CITY OF ALBUQUERQUE

Site: Juan Tabo Hills Estates

Re: Drainage Ordinance (14-5-2-1) Violations for Erosion and Sediment Control

BMP MAP LEGEND

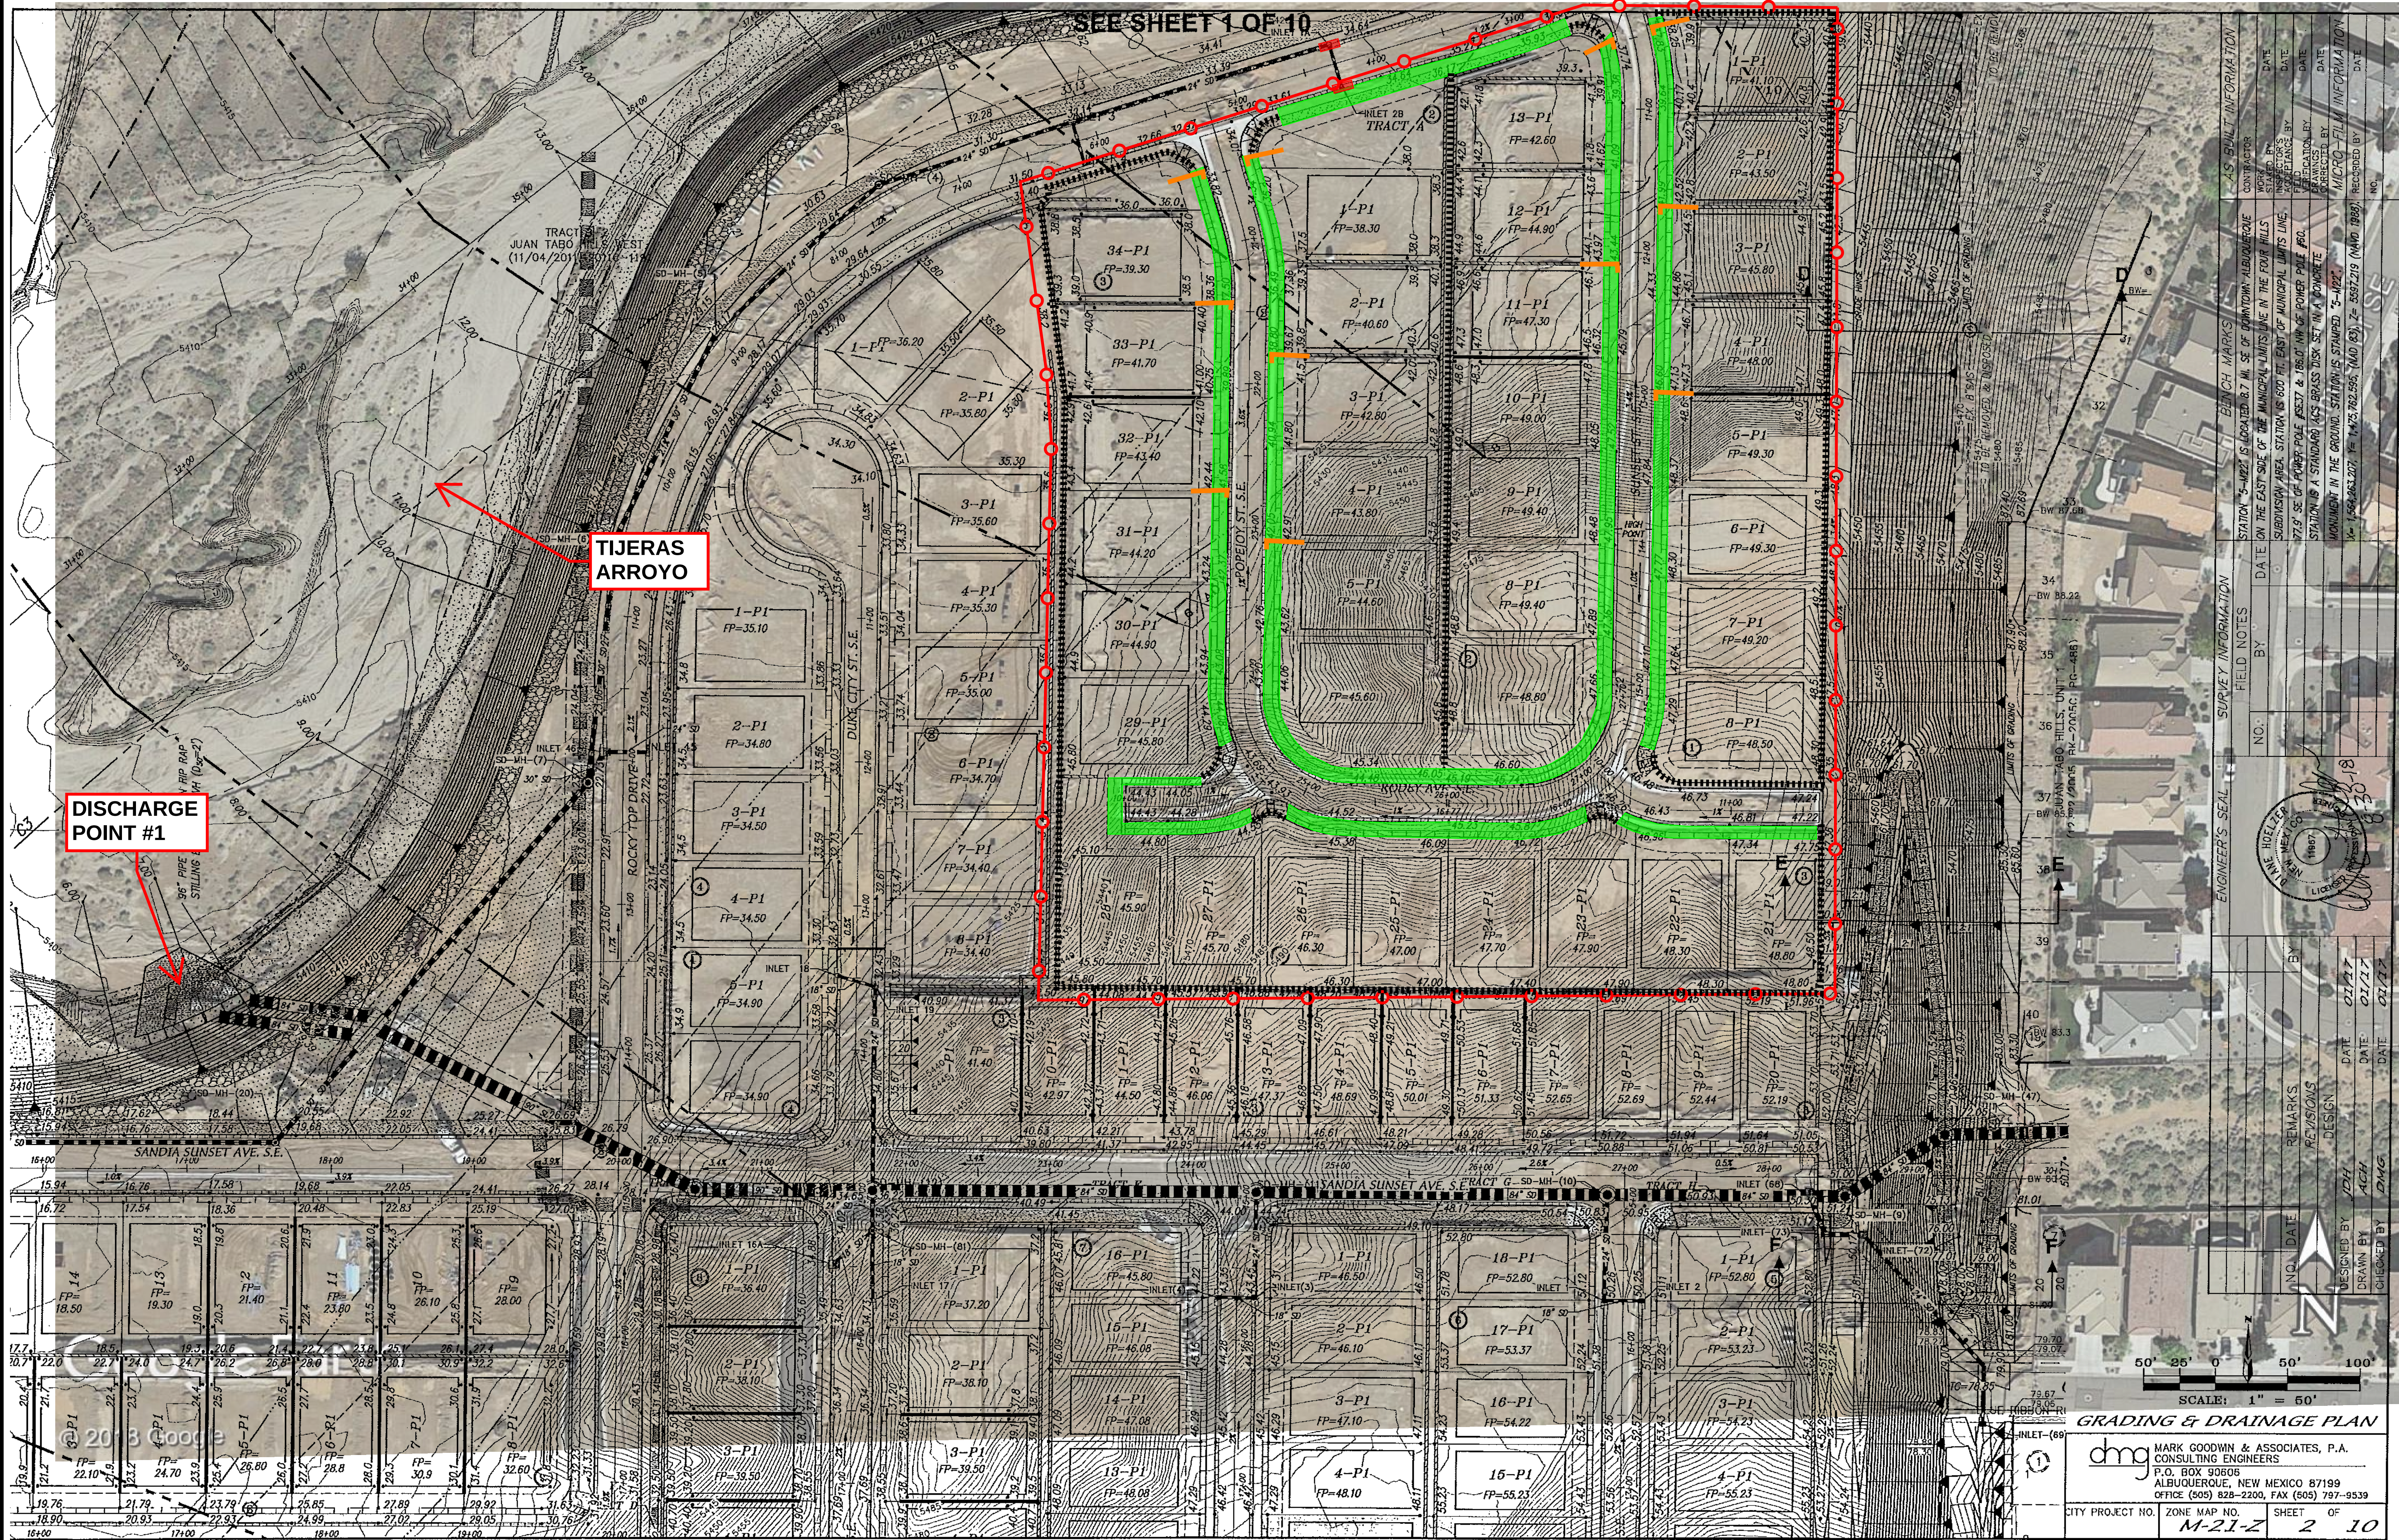
1. Silt fence is not installed properly, as it is not buried along the southern edge in the southeast areas of the site.
2. Grading in the southwest corner of the site directs flows into an undersized ponding area with an uncompacted berm rather than into the stormwater quality pond.
3. Loose soil in the low-flow area of the channel and berm not compacted adjacent to the arroyo.
4. Self-inspection reports were not provided upon request.

1. Reinstall silt fence per the approved Erosion and Sediment Control plan along the southern edge in the southeast area of the site. Silt fence is to be installed and maintained per the approved plan.

2. Regrade the berm/swale in the southwest corner of the site so that drainage will enter the stormwater quality pond.
3. Remove loose soil from the low-flow area of the Tijeras Arroyo. If a berm is desired next to the arroyo to direct flows out the work area it is to be compacted and look like a berm as shown on approved grading plans. Minimum compaction requirement is that an inspector should not sink into it while walking on it. Numerous trips over the berm with a large piece of earth moving equipment should be able to achieve this. Prevent loose soil from entering the low-flow area of the channel.
